Application No: A/266/21/PL
Site Address: Crete House The Beeches Dappers Lane Angmering BN16 4EN
Description of works: 2 No. 2 storey extensions, replace existing bay window with bi-fold doors on the existing dwelling and the construction of 2 No. 5 bed new dwellings. This application is in CIL Zone 2 and is CIL liable as new dwellings.

A/266/21/PL Crete House

We are writing to object to the proposal for 2 further houses on the Crete House site on Dapper's Lane, Angmering. Our objections are for the following reasons;

SITE PLAN & VISIBILITY SPLAY
1:200

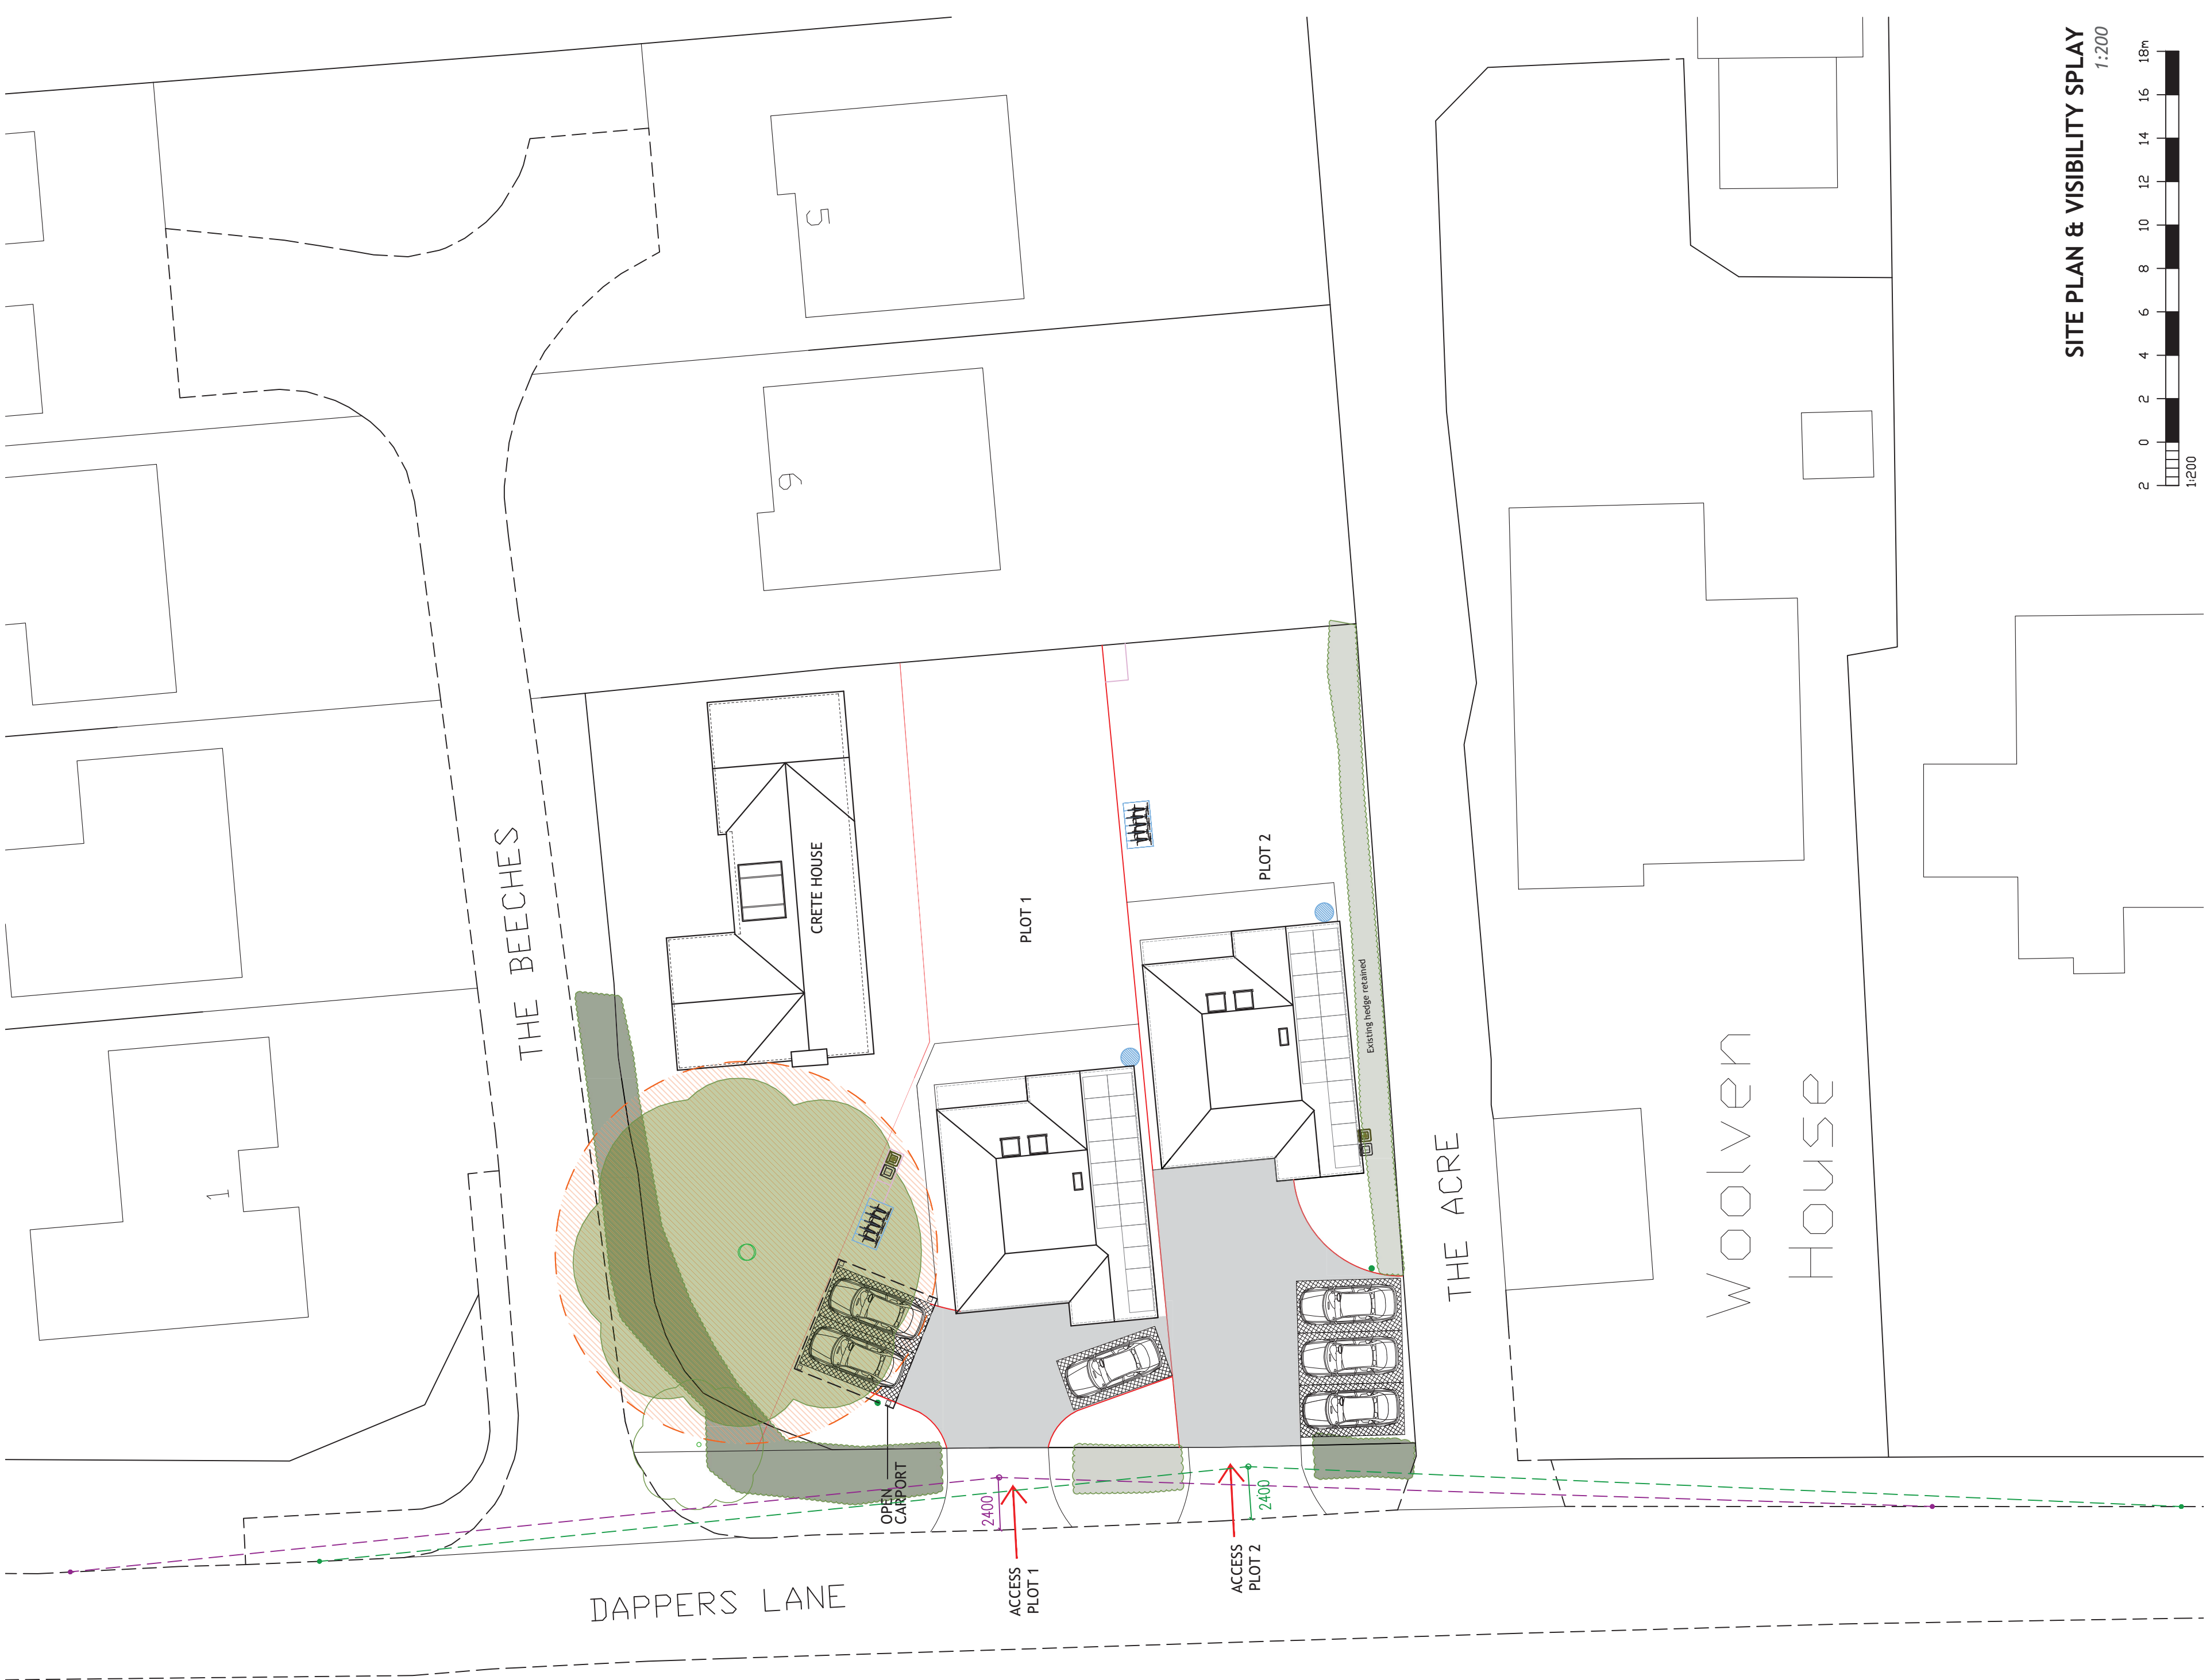
2 more drives exiting on to the lane in very close proximity to The Beeches and the industrial area will cause further danger to pedestrians, cyclists, horse riders and other vehicles which use the lane;

The oak tree has a TPO and must be protected to help biodiversity, judging by the logs on the grass either this tree or another has already been reduced / cut down. The plans show parking right up against the tree;
